Subject: FW: FP/103/19/PL - Appliation to replace sports pitch with a public amenity area, Site 6, Felpham

Subject: FP/103/19/PL - Application to replace sports pitch with a public amenity area, Site 6, Felpham
Importance: High

Please could you address our concerns regarding "DWG D1530 L320 REV E" which was submitted with planning application FP/103/19/PL.

Drawing Title:
CHANGING FACILITIES BUILDING
SITE LAYOUT

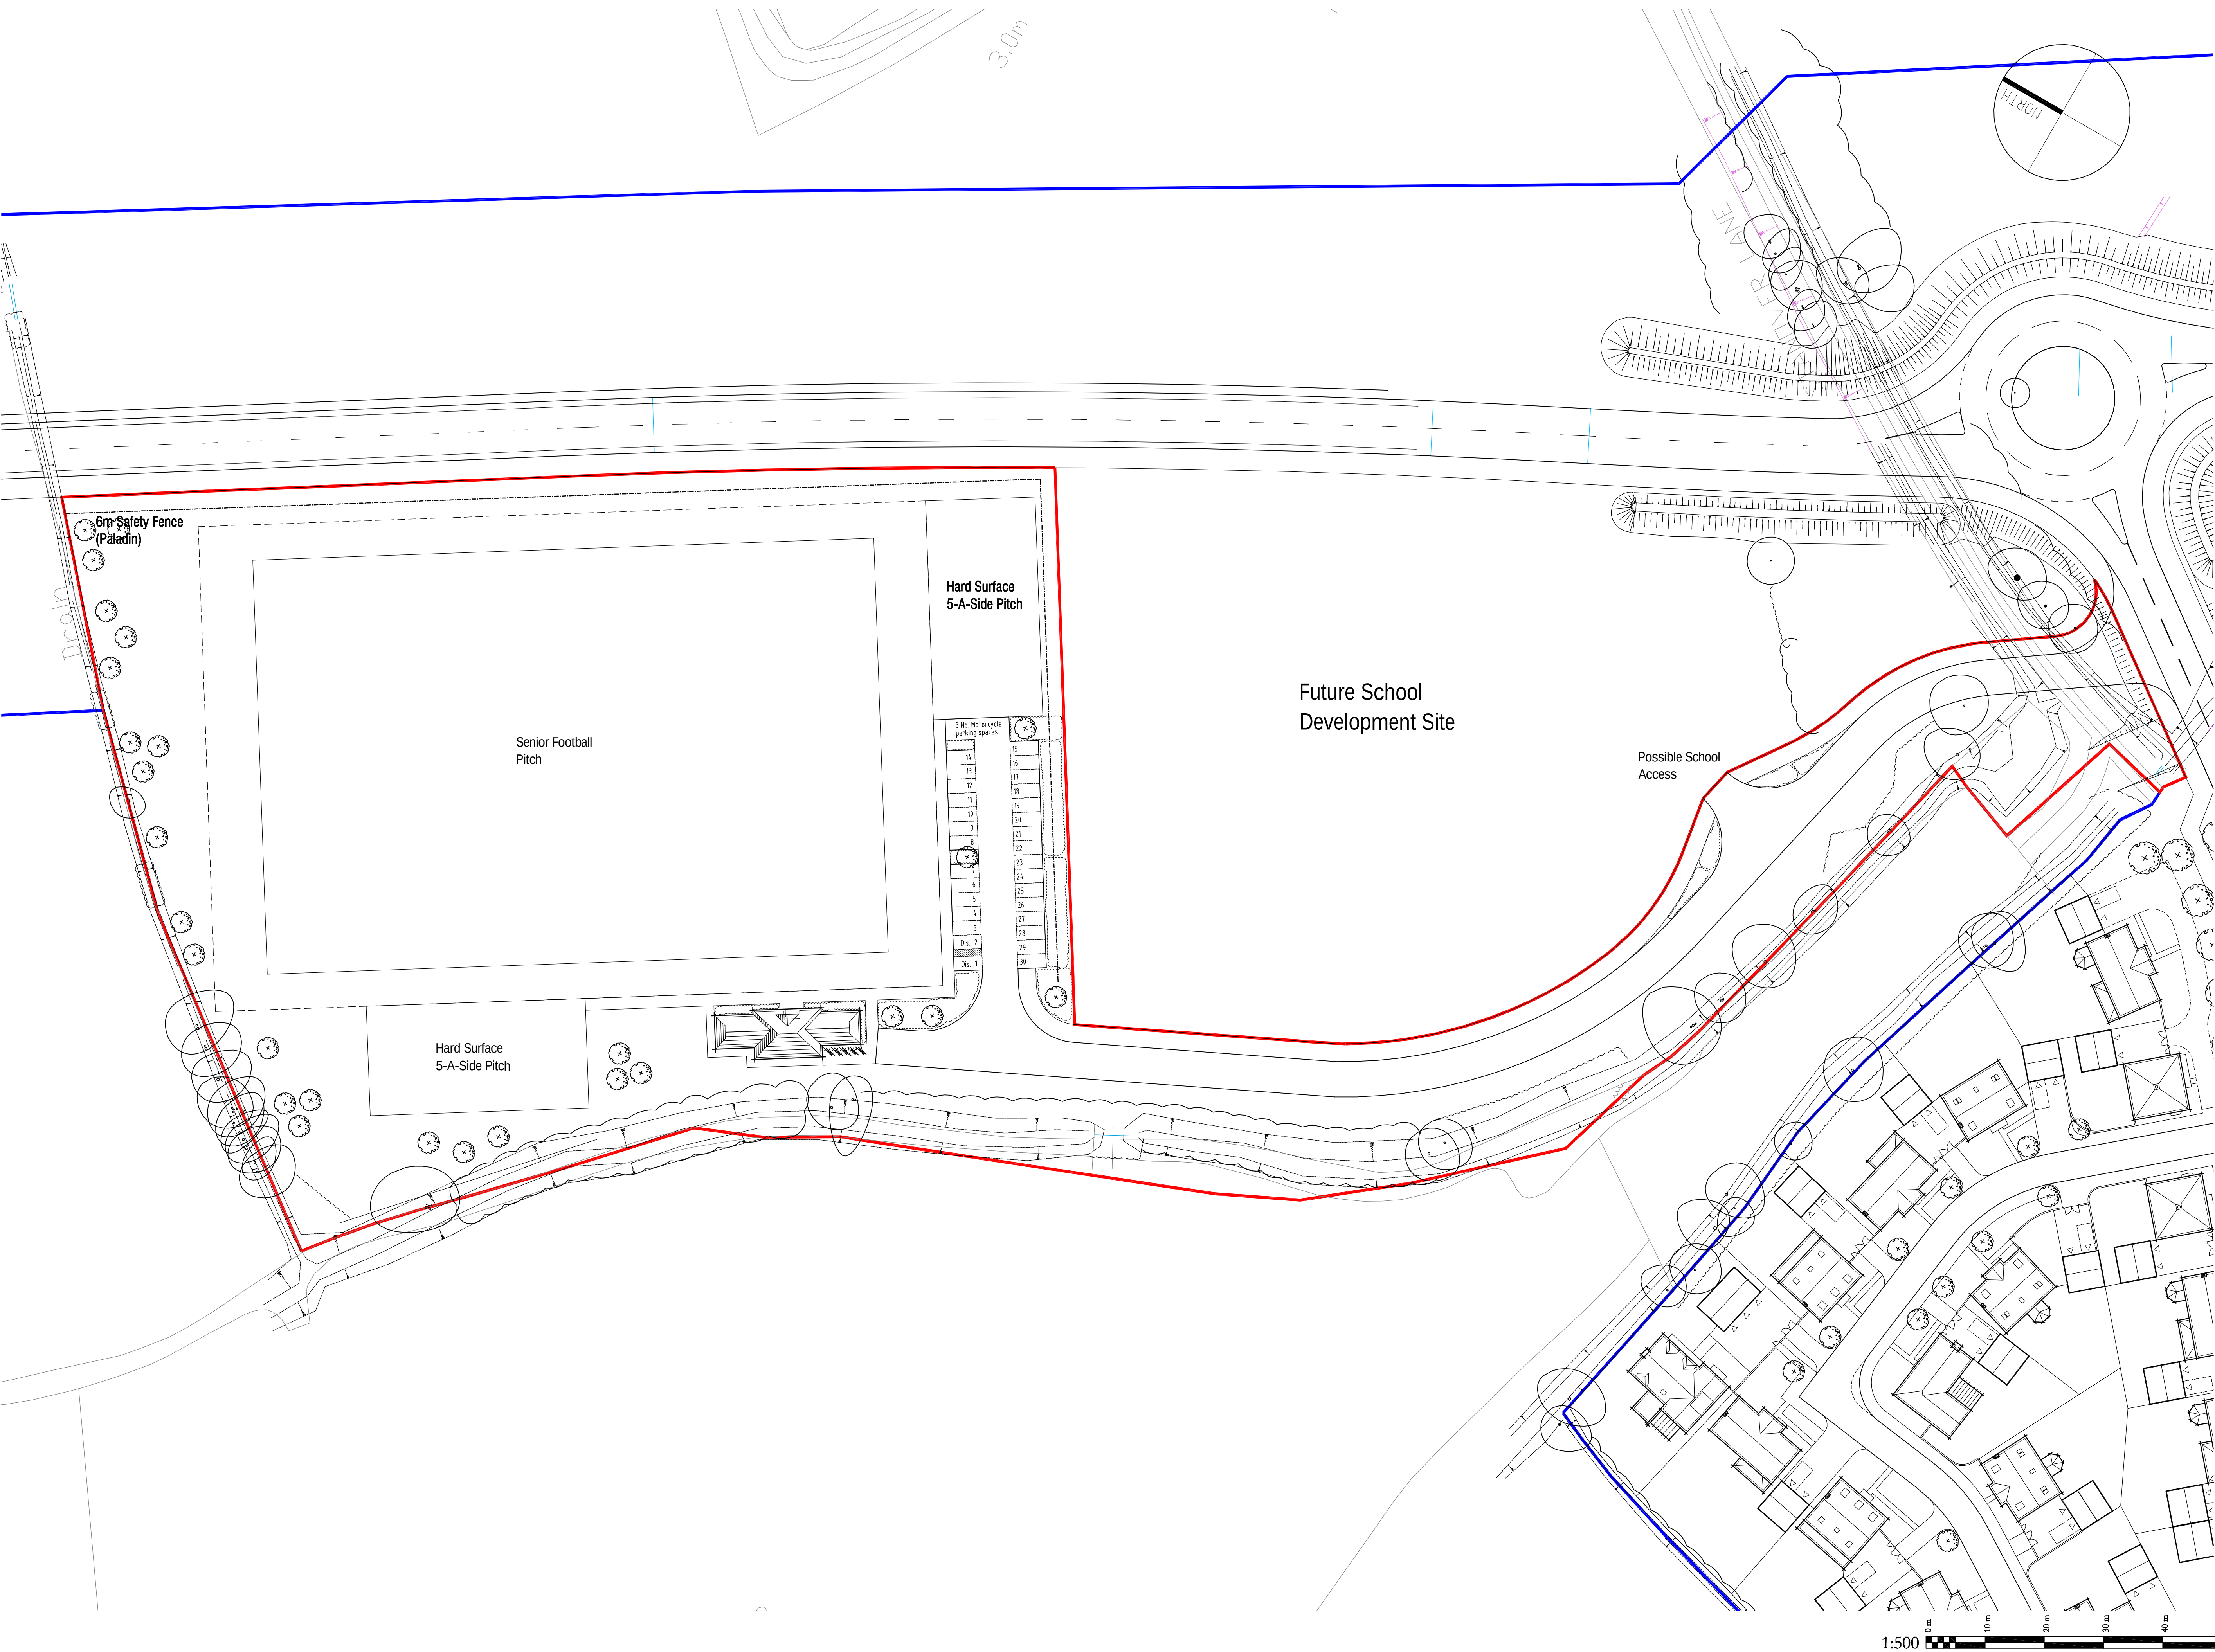
- The use of a cycle shelter (FT3) at this location is not appropriate – individual steel (stainless or similar) would be appropriate.
- Detail dwg to illustrate fencing (Boundary type 2) and security gate (FT2) for approval is required. Alternative to Boundary type 2 such as railway sleepers and a bund would be acceptable – detail to be approved.

- Detail of height barrier at FT1 to be approved – to include a gate to enable closure of car park.
- Specification of all tarmac surfacing, including sectional drawings and drainage must be provided for approval.

- Confirmation on the location of disabled parking – and that all areas to be line marked is required.
- There is no reference to the boundary fencing detail for large parts of the site – this must be provided. The site boundary must be clearly established on the ground in all areas.

- Allow for surfaced pedestrian access (tarmac or similar approved surface) at northern part of site to link with the pedestrian footpath onto the new relief road – detail drawing to be approved – this will need to allow for measure to prevent the access of vehicles.

- Provision of site furniture such as seating, picnic tables, bins and dog bins to be provided on site – detail and locations to be approved.
- Allowance for the provision of interpretation and access signs – details to be approved – is required.

- Drawing needs to identify existing native planting to relief road boundary – on the noise bund and either side of the acoustic fencing.
- Details of standard tree planting is required – specified species is not clearly identified – this must be provided for approval.

- Addition tree planting adjacent to the car park area is required.
- Additional native planting is required beyond the standard tree planting illustrated – similar in specification to the relief road planting. This needs to be provided in substantial areas adjacent to the site boundary.

- Two section drawings illustrating the levels across the site – including the access road / car park area is required for approval. Particular attention needs to be given to ensure levels marry in with surrounding landscape – particularly in areas where the ground is made up. Areas of ground must not be compacted; where this is evident in future years the developer will be required to make good.
